# DEVIATION REQUEST AND DECISION FORM

Project Name : Sterling Ranch Sand Creek Channel Construction Drawing Review CDR 20-4  
 Schedule No.(s) : 5227301021, 5233309027, 5228000030 & 38, 5233301001 5233301016 & 17  
 Legal Description : See Exhibit B – Legal Description

A deviation from the standards of or in Section **ECM section 3.3.3 Open Channel Design Standards** of the Engineering Criteria Manual (ECM) is requested for the Sand Creek Channel Design – Channel Perimeter Fencing.

Exhibit A
Fencing Detail

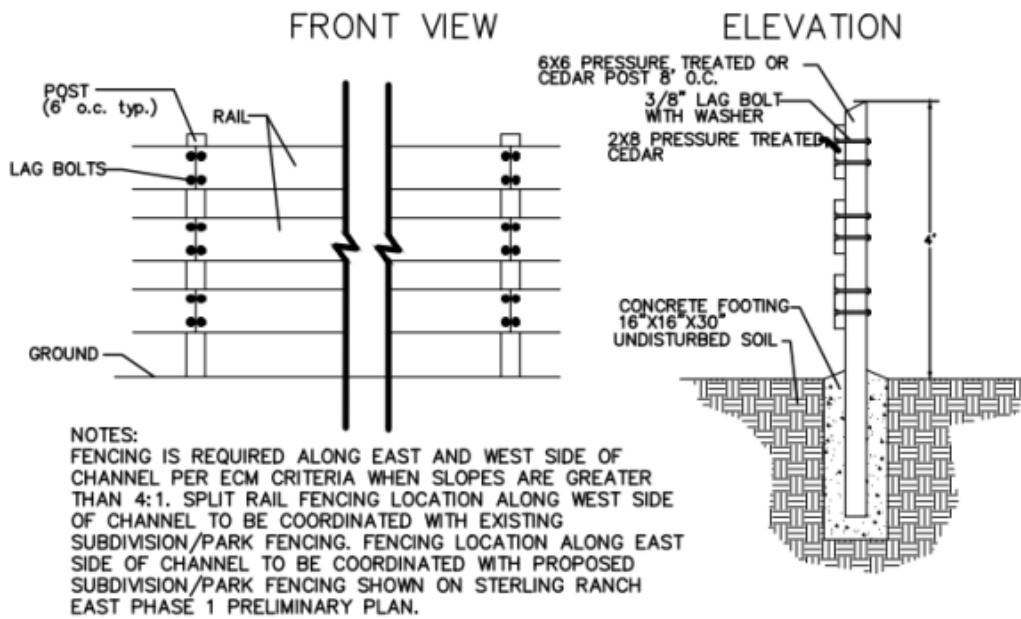
Sterling Ranch is requesting to use a more aesthetically pleasing split rail fence design as shown in exhibit A

The vast majority of the channel side slopes or 4:1 or flatter, however in some isolated areas a 3:1 slope is necessary and those areas will require fencing. When that condition exists Sterling Ranch proposes to use split rail fencing similar to the detail shown in Exhibit A.

This request has been determined to have met the criteria for approval. A deviation from Section 3.3.3, Item K.4. of the ECM is hereby granted based on the justification provided.
